Rezoning Transportation Analysis

Petition Number: #2021-256

From: Jake Carpenter, PE
Jacob.Carpenter@charlottenc.gov
980-221-5675

Date	Description
04-12-2022	First Review (AO)
08-22-2022	Second Review (AO)
01-25-2023	Third Review (TM)

DEVELOPMENT NOTES

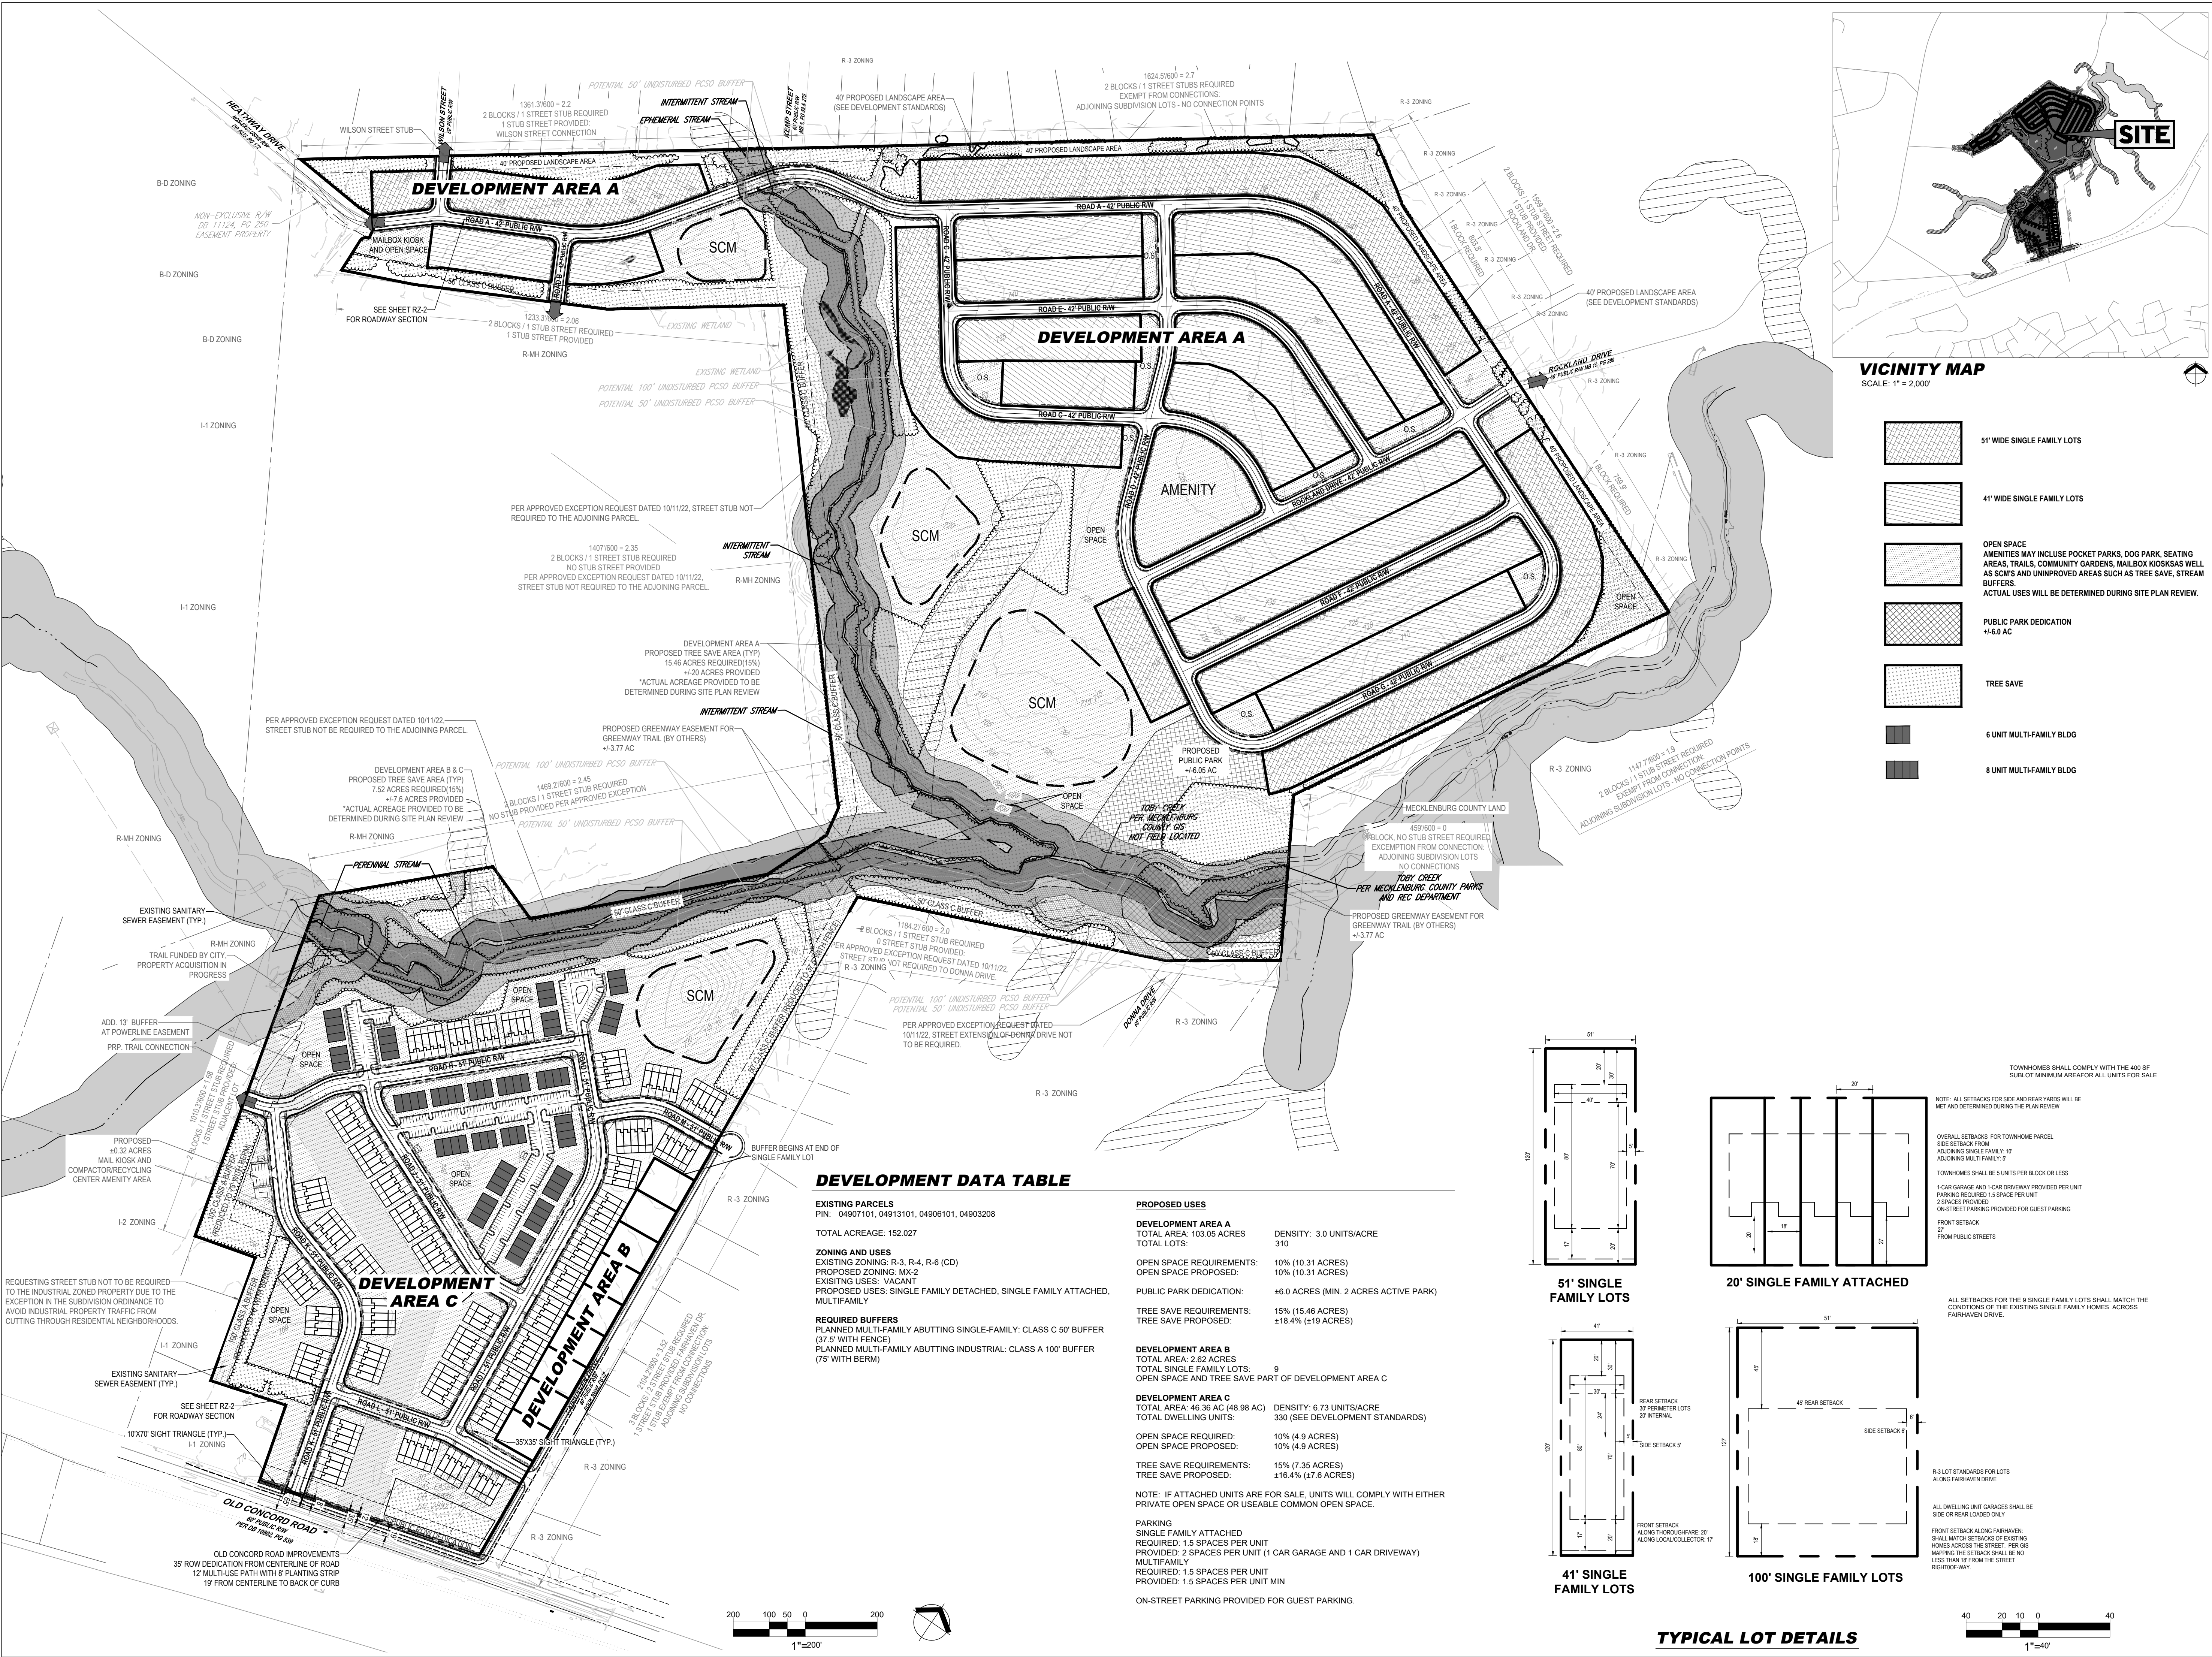
Comment Rescinded (01-25-23): Add multi-use path to site plan sheet RZ-3 and add conditional note to development standards.
